From: [Dave Aube](#)
To: [Webb, Robert L.](#)
Cc: [Shannon VanDusen](#); [Emily Brudenell](#)
Subject: Re: 1300 Britt
Date: Friday, May 26, 2023 10:41:35 AM
Attachments: [image.png](#)
[image.png](#)
[image.png](#)
[f8a72e7d-2df9-4308-9a44-95579fc7eecb.png](#)
[image.png](#)
[A201.pdf](#)

1300 Britt

I had a couple questions on the AA submittal.

SHEET TITLE  
PROPOSED SITE DEVELOPMENT PLAN FOR BUILDING PERMIT

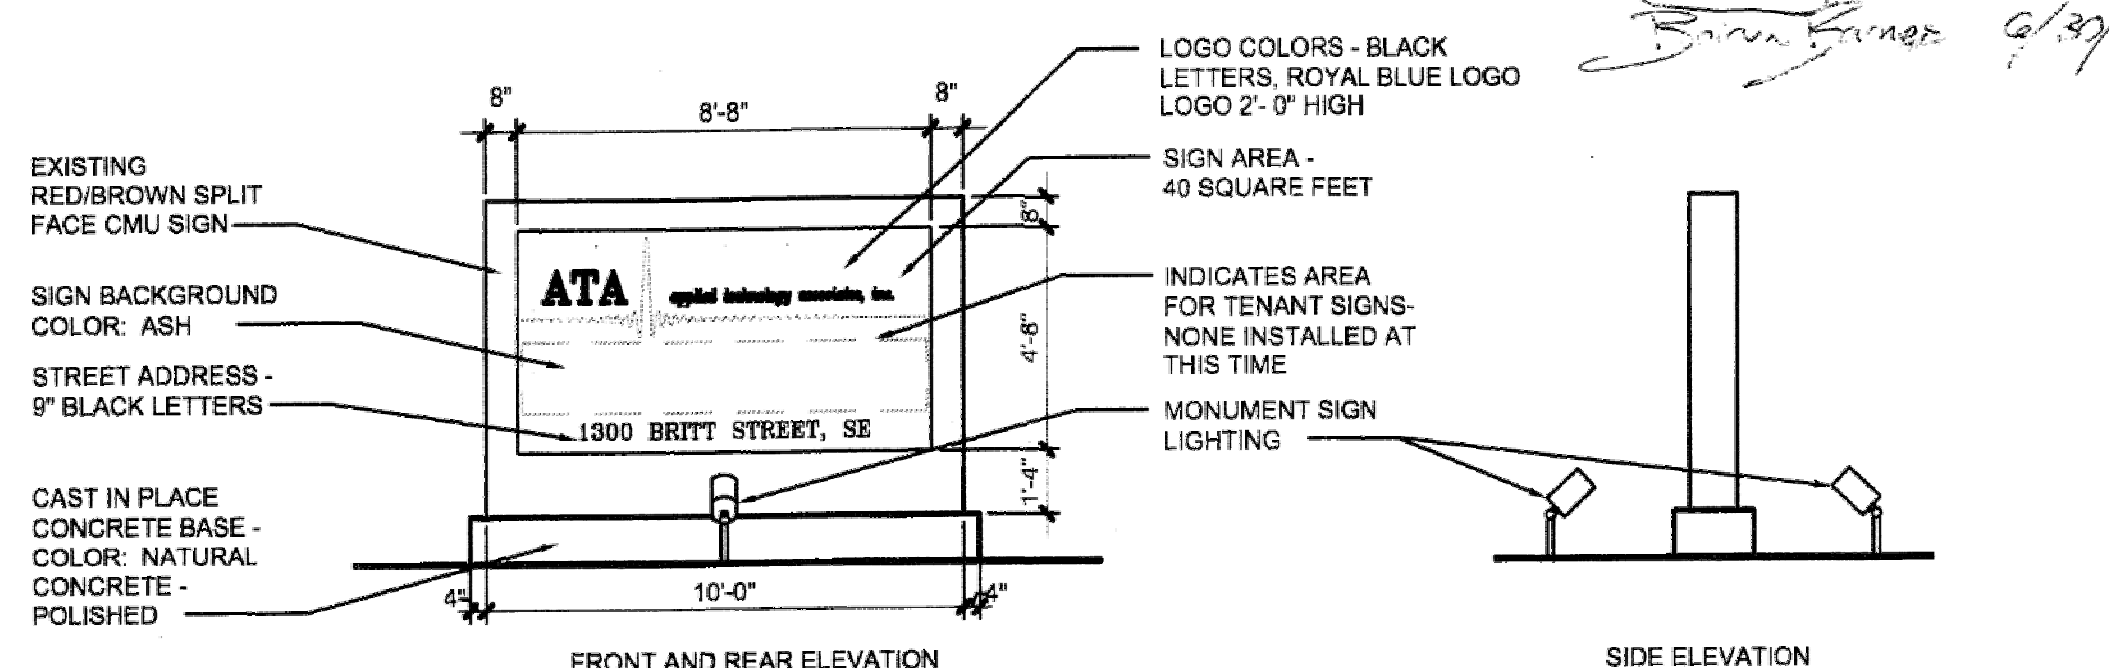
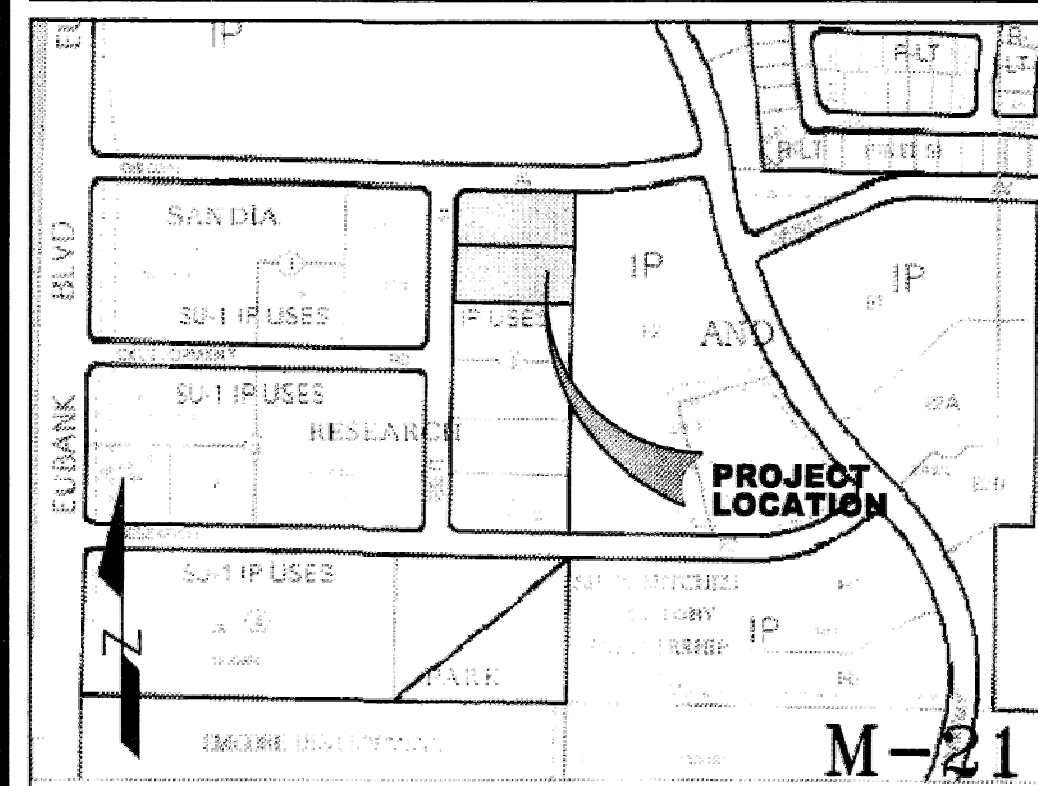
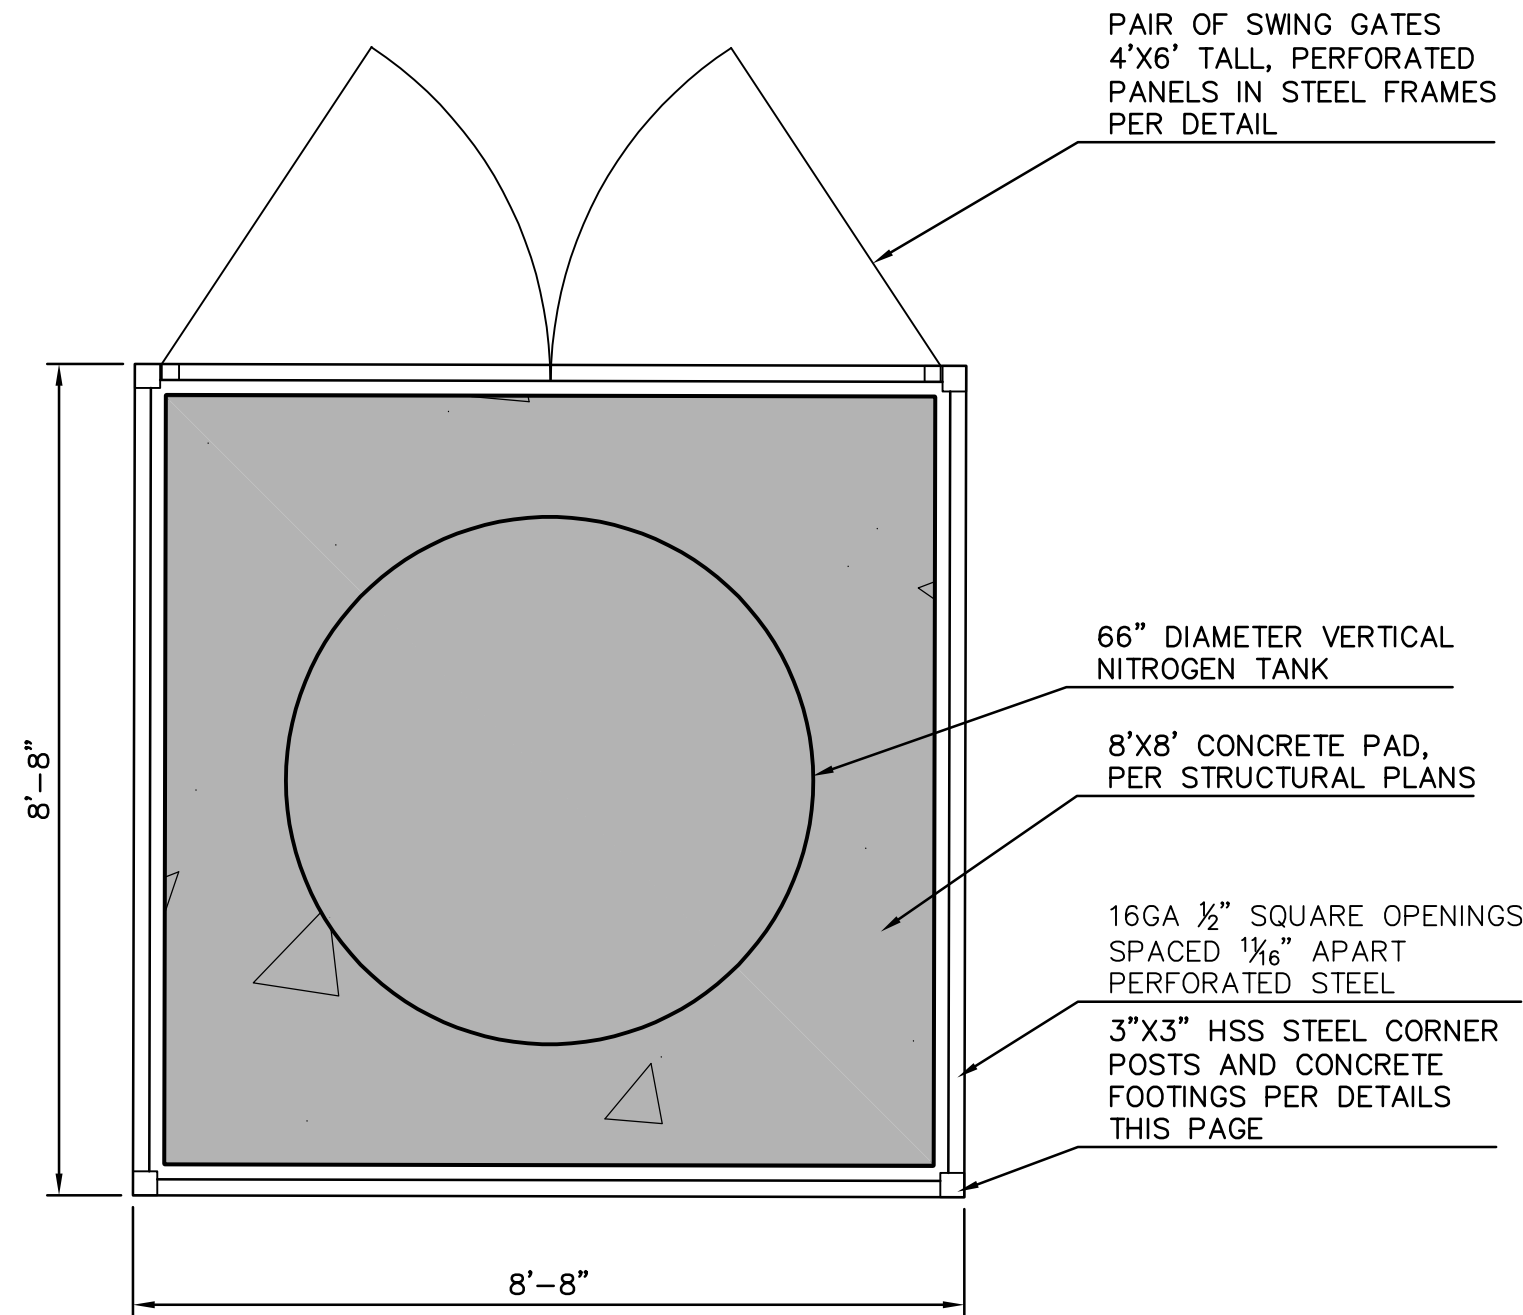
*Landscaping is being reduced.

Will it still meeting the standards of the original plan?

Or are you adding in another area?

*Parking is being reduced

Will it still meeting the standards of the original plan?

*For the façade design, will the addition match the existing building?

Please include elevations.

As far as the Landscaping, we are proposing a reduction of 735 sf. We are required a total of 4011 sf, and will still have 8,435 sf on site.

Below are images from the AA we submitted that identify the required and provided totals. The image with the red revision clouds is the proposed condition. The black and white image is from the Site Plan from 2009.

As you can see the Net Lot area was slightly reduced (thus reducing the required sf). We are still well above the required and have reduced the provided landscaping by less than 10% (actually 8.2%).
